Amendment: Window detail amended
(Dwg no. 2041-2)

Planning Application H13/1236/00.

Erection of a single storey part two storey rear extension, 3 Fengate, Moulton Chapel - Mrs Lockie.

DATE	SCALE	JOB No
		2041 ~ 2
DATE REVISED	DETAILS

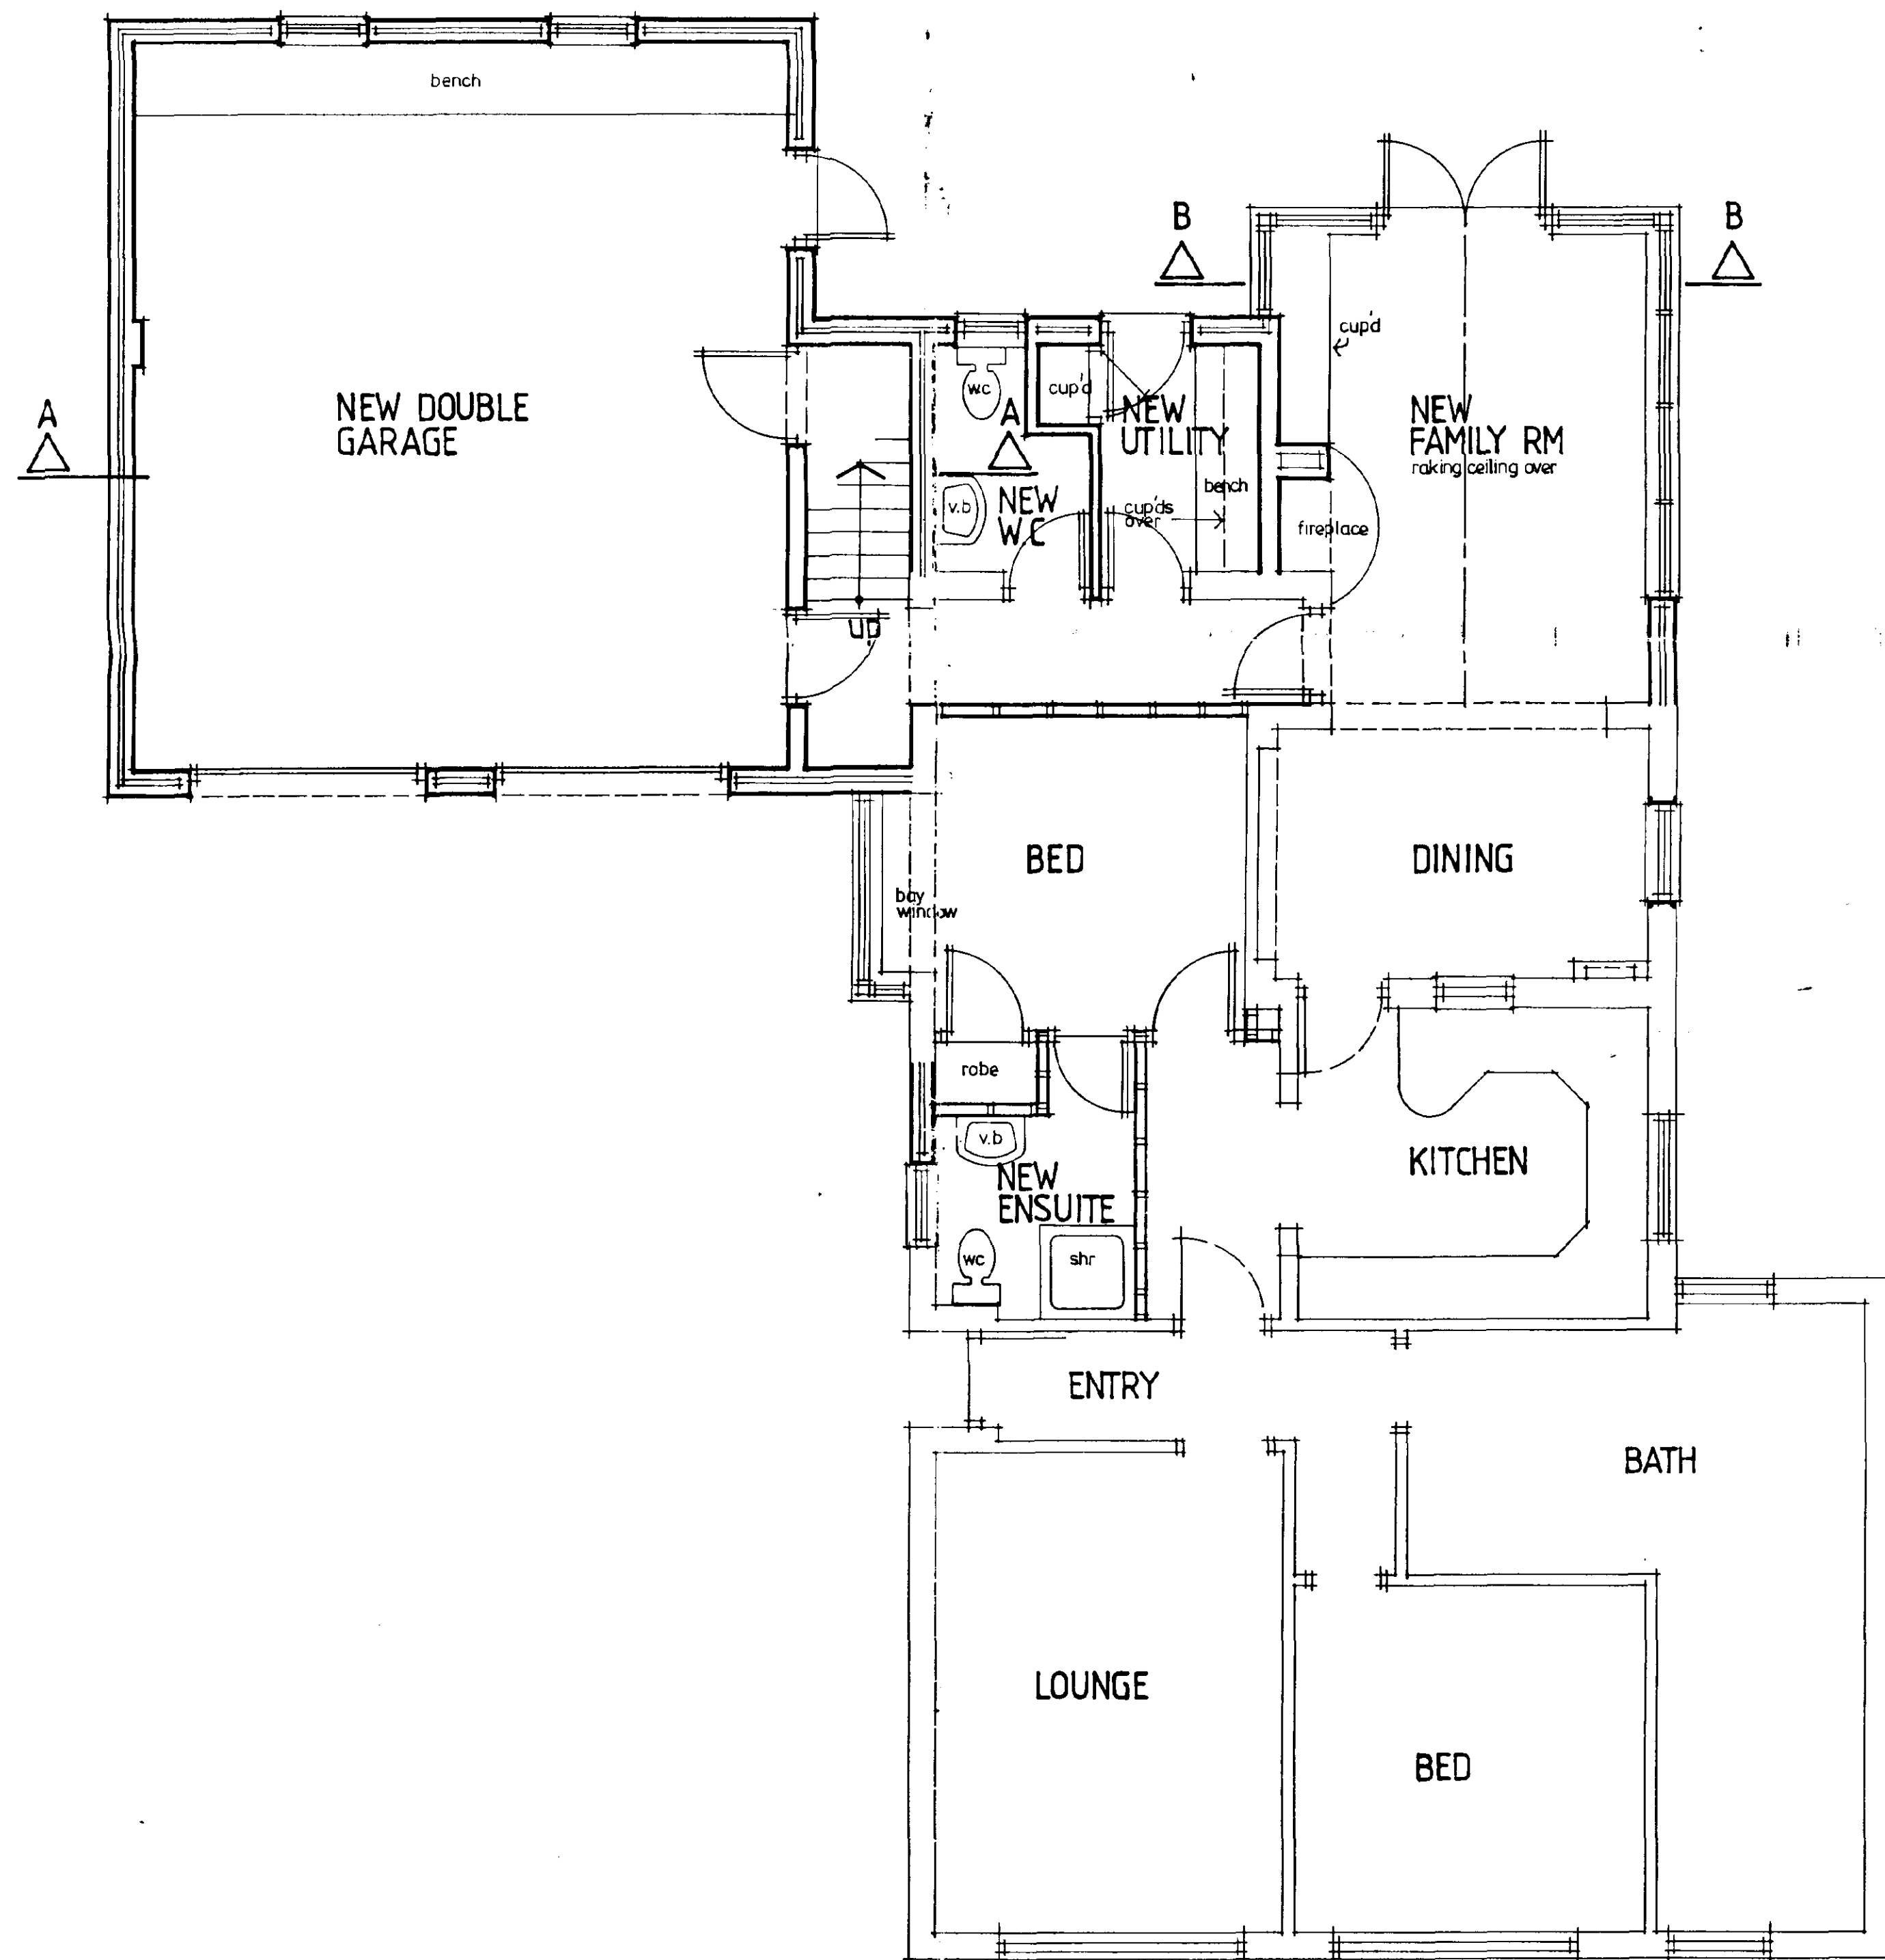
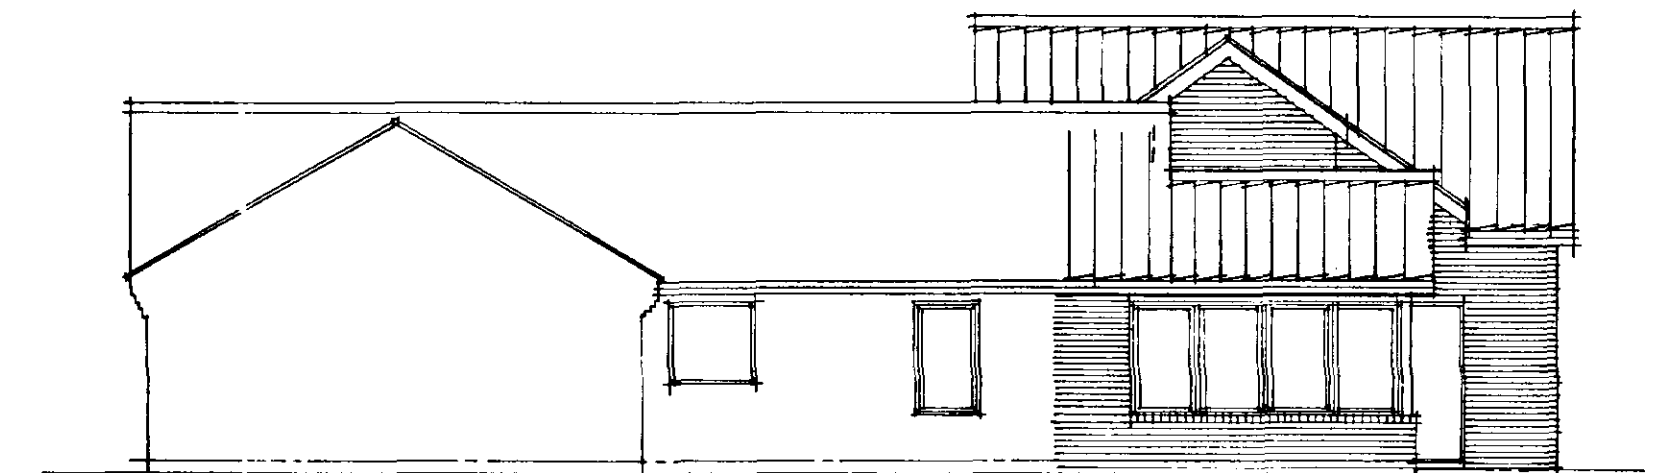
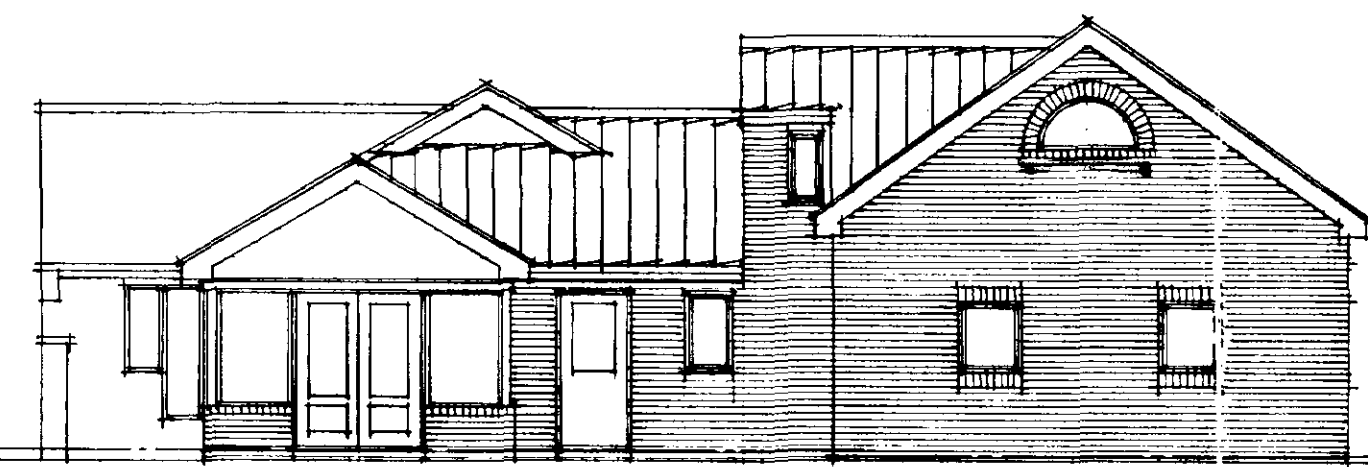
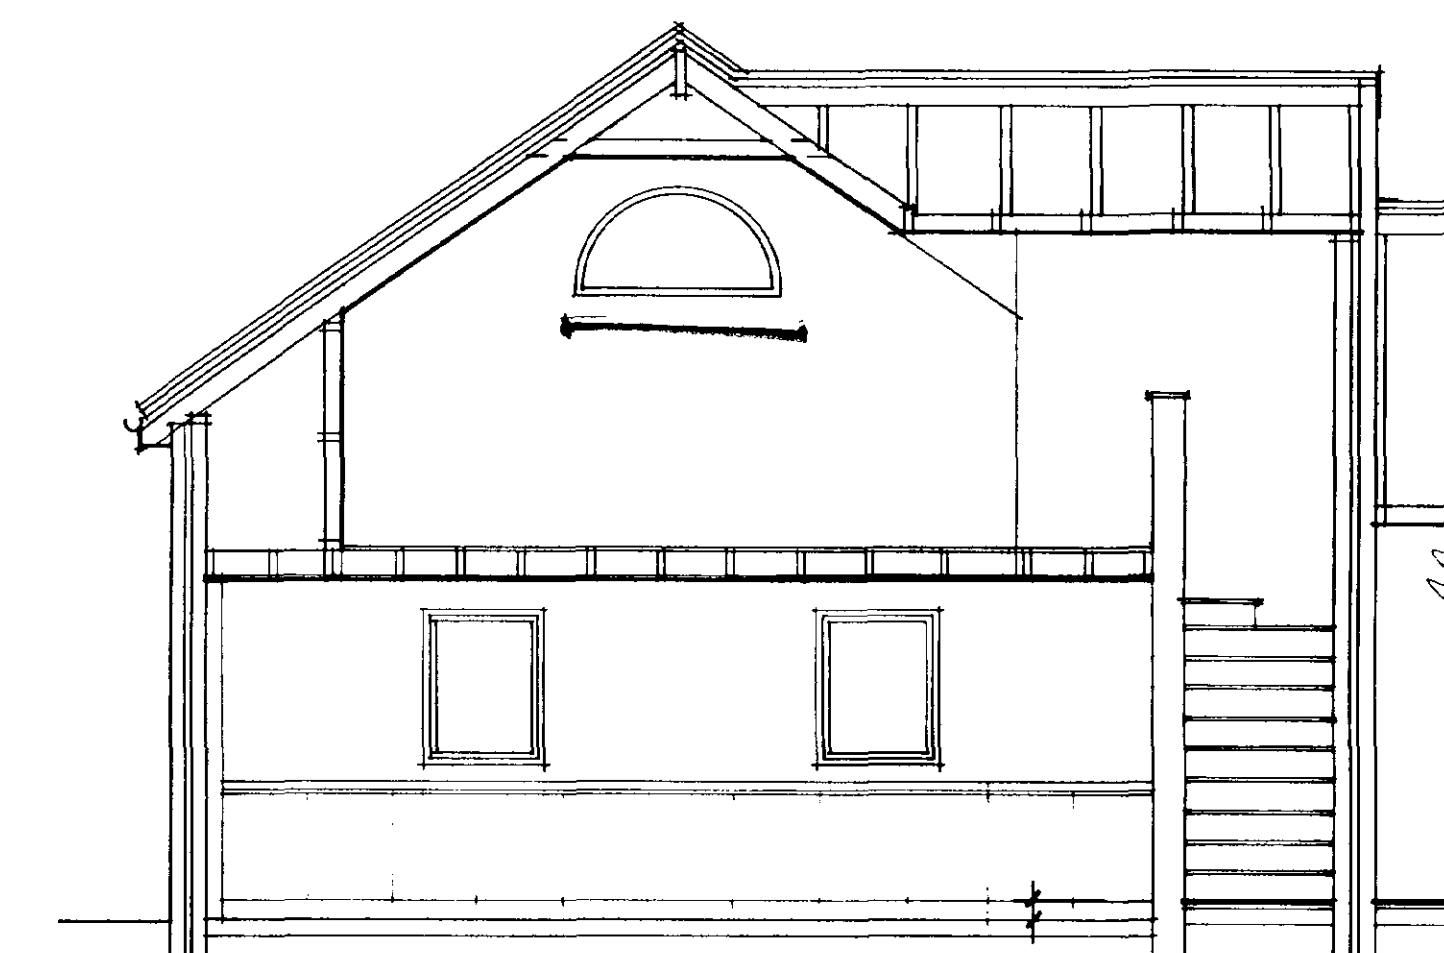
It is noted that the proposed extension has a new rear window at first floor level. This is in relatively close proximity to the eastern boundary and as such would overlook new development presently under construction.

It is therefore considered that this window should be deleted. If you need an alternative light source no objections would be raised to the provision of roof lights, preferably on the southern elevation.
